From: Stephen Gee [REDACTED]
Sent: 03 October 2018 16:21
To: Sam Sykes; Michael Eastham
Cc: Chris Barker
Subject: RE: P1456 A/38/18/RES - Manor Nursery site, Angmering - Cycle Route

APPLICATION NO: **A/38/18/RES**

Description of Works: Approval of reserved matters following outline consent A/51/14/OUT relating to appearance, landscaping, layout & scale for demolition of the existing Manor Nursery Garden Centre & hard standing & redevelopment for 32No. dwellings with associated access, public open space & landscaping.

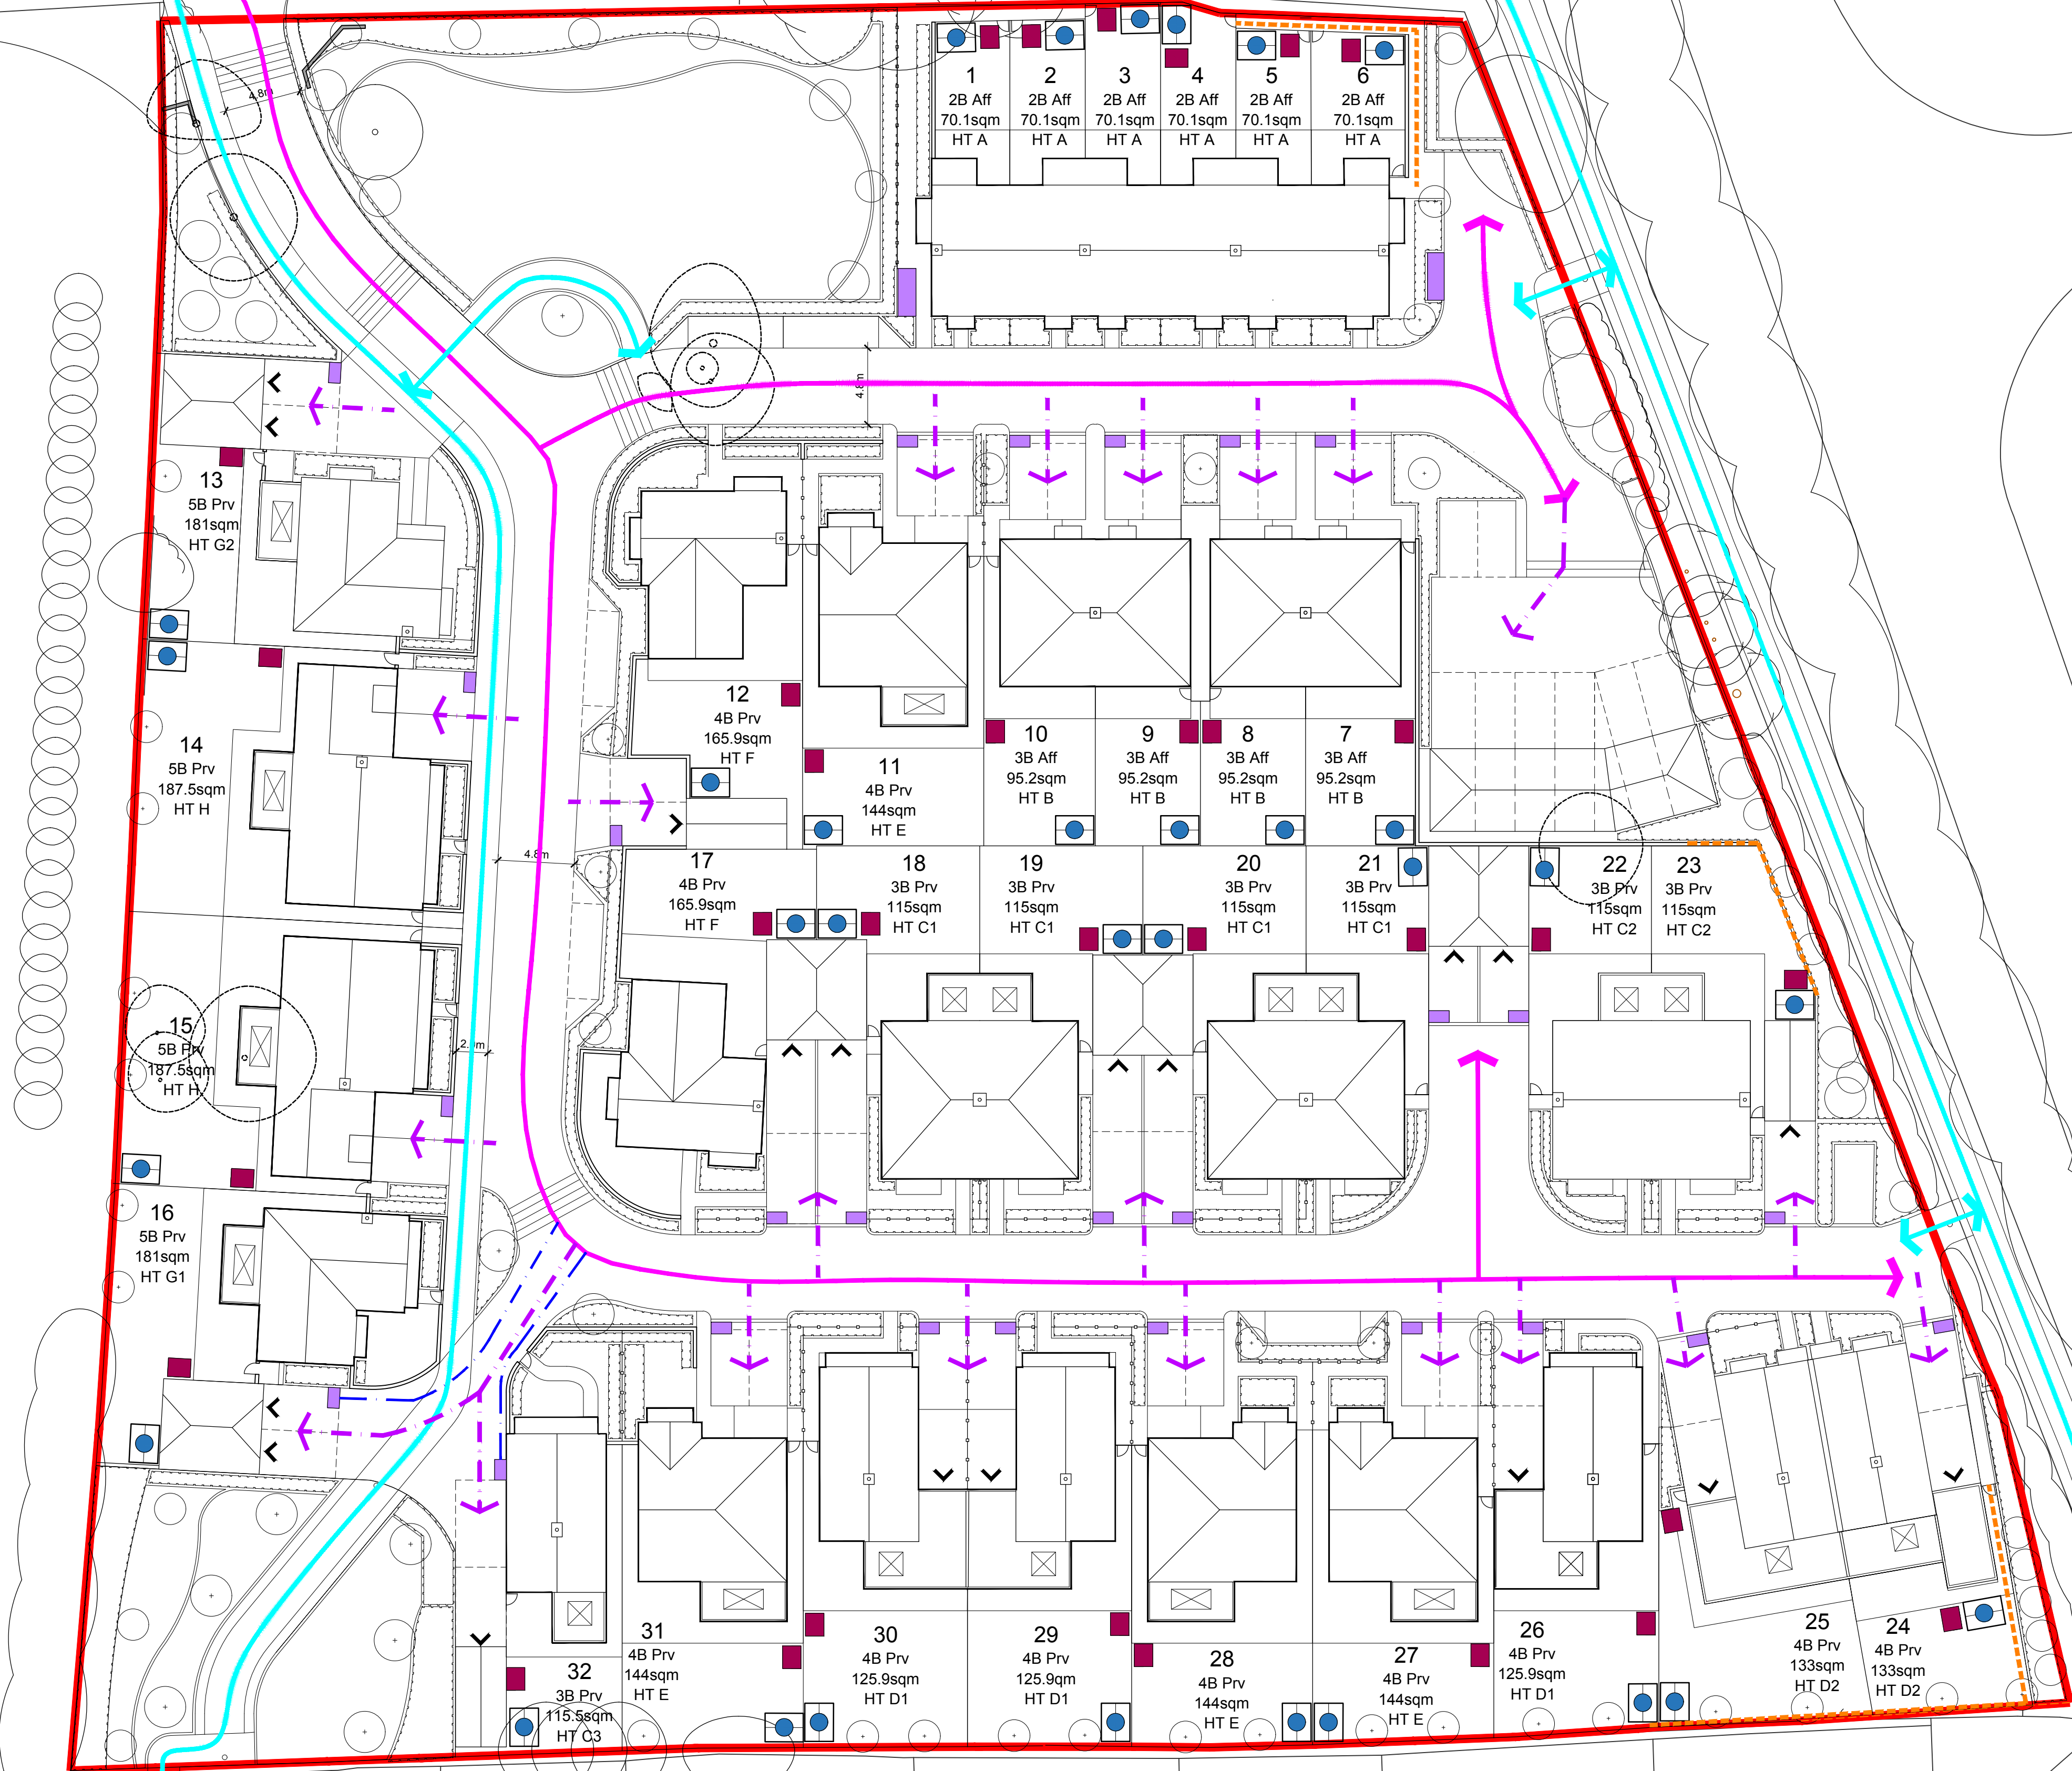
- Drop kerbs would be required on Nanson Lane and would be agreed at detailed design stage (as suggested in correspondence below).
- The use of grid system (grasscrete) to provide the additional width for an emergency vehicle is unlikely to be adopted by WSCC.

As you point out A/82/12 has been laid out without any off road cycling provision and as such cycling would be on road. The provision of cyclists dismount signs wouldn't provide a continuous cycle provision between the two sites.

I have discussed the matter with the highway agreements team who informed me a certificate for adoption has not yet been issued for the A/82/12 site. Is it the intention that your site (and specifically the cycle route) will be offered for adoption? If so the finer details of a link arrangement could be agreed at a detailed design stage with the potential for amendment of the kerb line at the north end of Nanson Lane.

From viewing the amended plans I can see that the applicant has amended the proposed site layout drg100 RevP6. plan to provide a 'wider pedestrian footpath' across the public open space into the A/82/12 site at Nanson Lane however the plan has not addressed my concern of measures to enable cyclist to re-join the carriageway at the southern extent.

As such this would not be sufficient to address condition 29 of the outline consent for the site (A/51/14/OUT (detailed below)) as it would leave cyclists on an existing footway on the eastern side of Nanson Lane.

Please refer to the attached amended layout showing an alternative configuration for the access in the south west corner of the site. The pedestrian / cycle access has been amended as follows:

- Realigned to adjoin the vehicular access at site A/82/12 to the south. This addresses WSCC comments regarding cycle access onto the highway.
- Realigned pedestrian footpath to adjoin existing footpath at site A/82/12 to the south.
- Strip of ground reinforcement grid system either side of the pedestrian / cycle path to a width suitable for emergency access in the south west corner. The grid system proposed would allow for emergency access whilst also allowing for grass growth through the grid (thus reducing the visual impact of the proposal within the area of open space). This access has been tracked as illustrated in the attached plans. Emergency access is a requirement under Condition 29 of the Outline application.
